27<sup>th</sup> April 2016

### **Crime Impact Statement**

Planning Application 3/2016/0344 Reserved matters of layout, scale, appearance and landscaping for a residential development for the elderly, comprising of 37 bungalows and 40 retirement apartments at Land at Accrington road, Whalley.

Drawing title:
Detailed landscape proposals

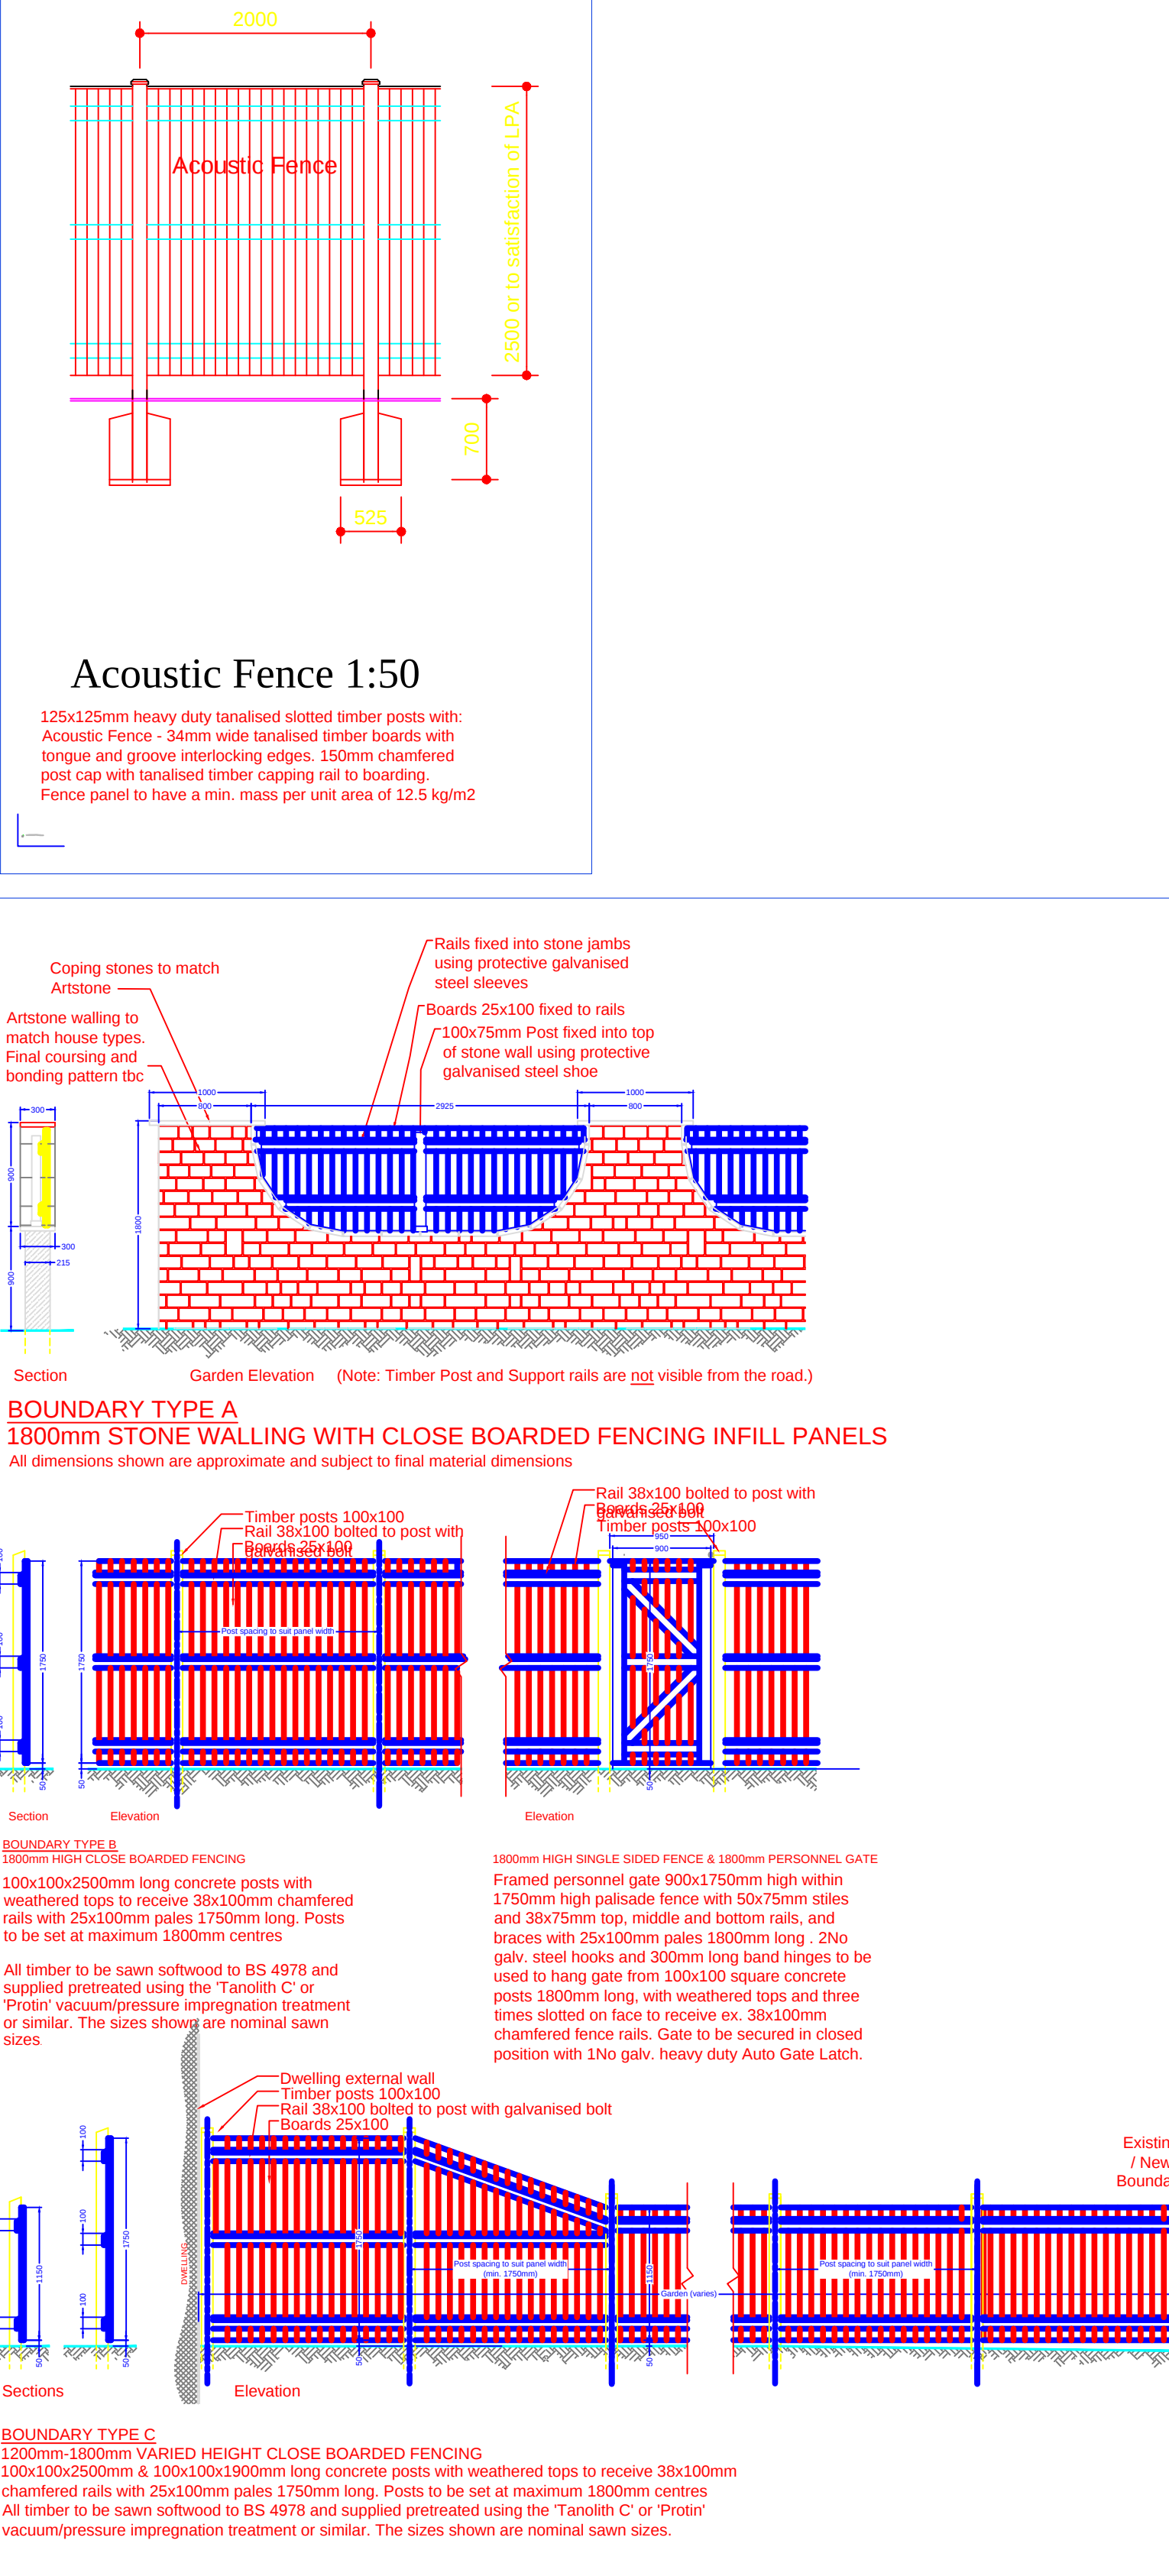
- Access gates to rear gardens should be 1.8m in height and lockable from the inside. All cross rails should be fixed on the rear garden side so that they cannot be used to enable climbing from outside.
- Lighting should be installed at all external doors to promote natural surveillance, promote feelings of safety and deter nuisance and criminal behaviour.
- All doors and windows should be certified to PAS 24:2012 or an alternate accepted security standard. This is now a requirement of Building Regulations Approved Document Q which will be satisfied by building to SBD. Front doors must have spyholes and door chains or restrictors fitted.
- All bungalows should be installed with either an intruder alarm or a 13amp non-switched fused spur suitable for an alarm to be added by the occupants at a later date.

- All opening windows must have restrictors fitted to reduce the risk of opportunist intruders taking advantage of windows left open. This MO is more common during summer months.
- Natural surveillance should be promoted as much as possible as this deters intruders as the chance of being seen is higher.
- Dwellings which back onto wooded areas or public open space could be more vulnerable to burglary as there is a concealed approach available. The areas of planting marked 'riverside scrub mix' should include defensive (thorny) planting such as hawthorn which is effective at deterring attempts at entry and should be added to the outer edge of the fence line along these areas.

- Access to the rear garden areas of the apartments should be restricted – if free access is available to this area this would significantly increase the risk of crime and nuisance, especially to ground floor apartments.

- Landscaping should be kept below 1m in height to reduce the risk of obstructing the spread of light and creating places to hide.
- External lighting should illuminate car parking areas and footpaths to deter criminal and anti-social behaviour and promote safe use.
